MORGAN AND MORECAMBE OFFSHORE WIND FARMS: TRANSMISSION ASSETS

Response to Section 51 advice

December 2024

Document reference: S_S51_1

Drawing Number:
BP-GBR-MORG-REG-0184

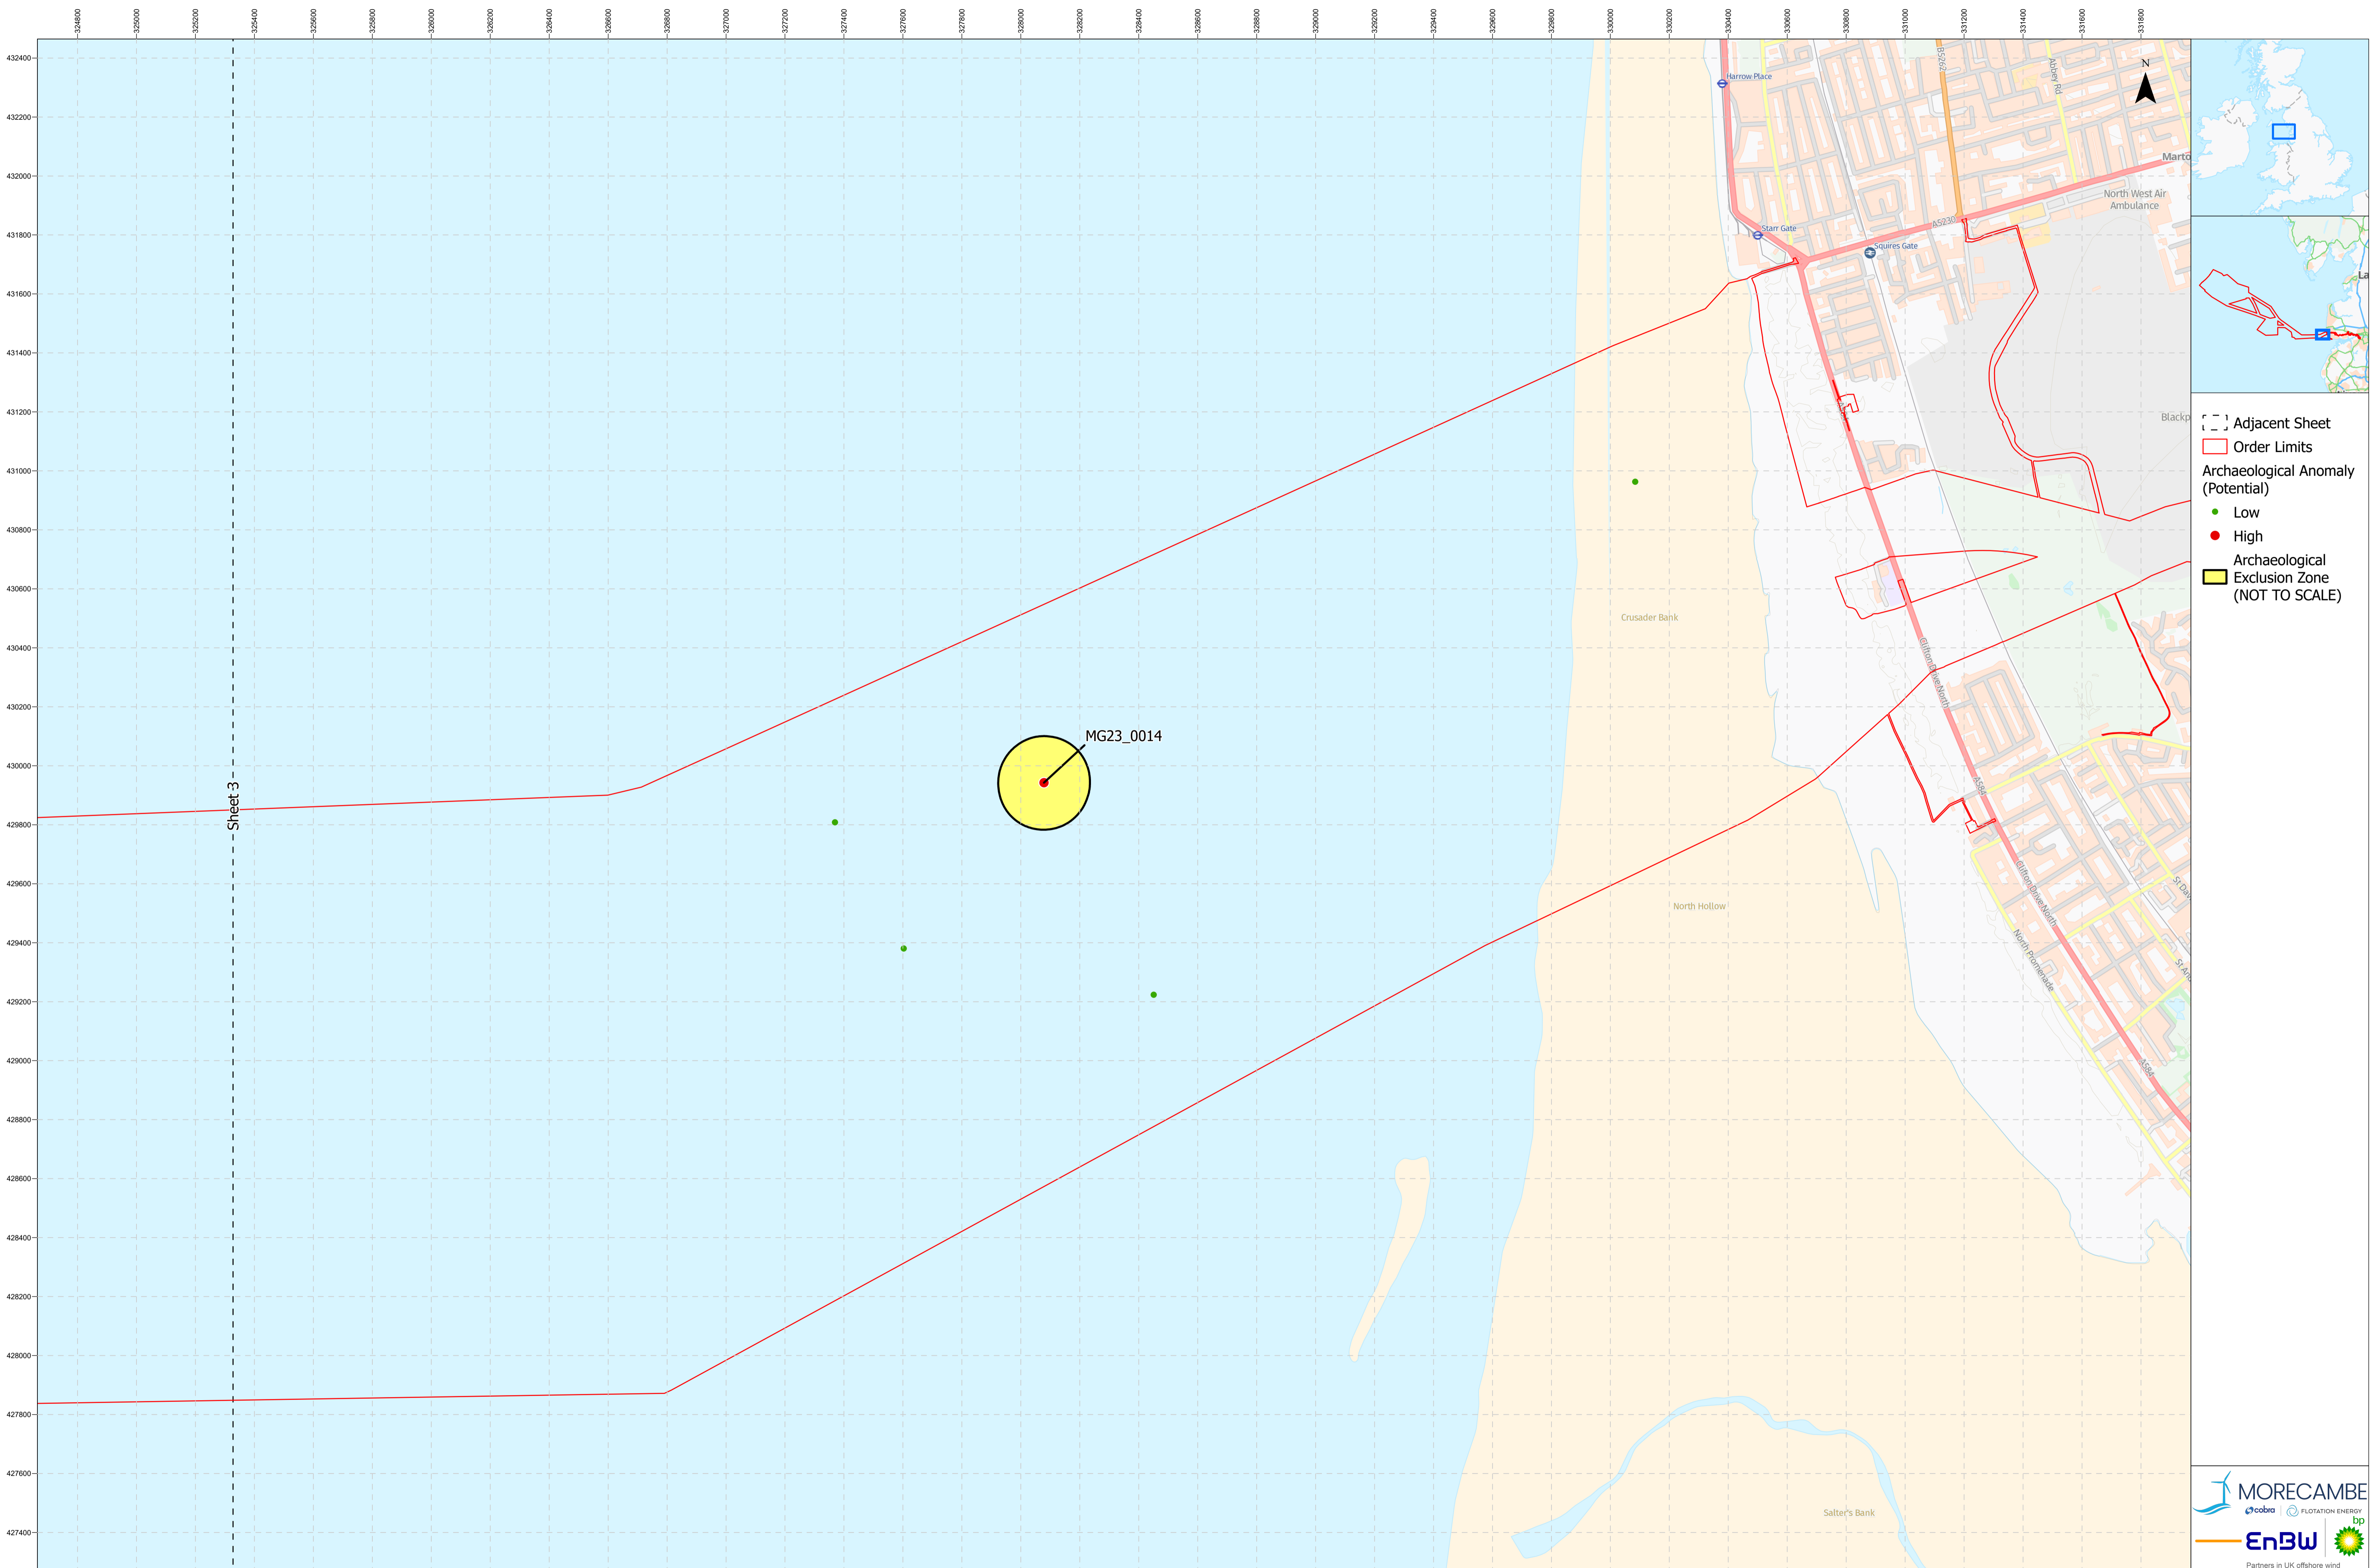
Topic	Section 51 advice	Applicants' response
		reference: B16/F02) to the Planning Inspectorate. The document also contains a Schedule of Changes.
Statutory and Non-Statutory Features of (The Offshore) Historic Environment Plan	<p>“Standalone figure B17 (Statutory and Non-Statutory Features of (The Offshore) Historic Environment Plan) only shows offshore exclusion areas rather than specific features, however the specific sites are shown on the ES figures. The Applicants are advised to provide an updated set of figures with appropriate labelling of the features being represented.”</p>	<p>The Applicants have reviewed the Offshore Historic Environment Plan alongside the ES Volume 2, Figure 8.5 and can confirm that the location of the geophysical anomalies shown as high medium and low are the same.</p> <p>The Applicants have reviewed the Offshore Historic Environment Plan alongside the ES Volume 2, Figure 8.6 and can confirm that Archaeology Exclusion Zone (AEZs) and Temporary Archaeology Exclusion Zones (TAEZs) are the same. To enable cross-referencing between the documents, named wrecks have been added to their corresponding ID reference. The Applicants have submitted the updated Offshore Historic Environment Plan (document reference: B17/F02) to the Planning Inspectorate. The document also contains a Schedule of Changes.</p>
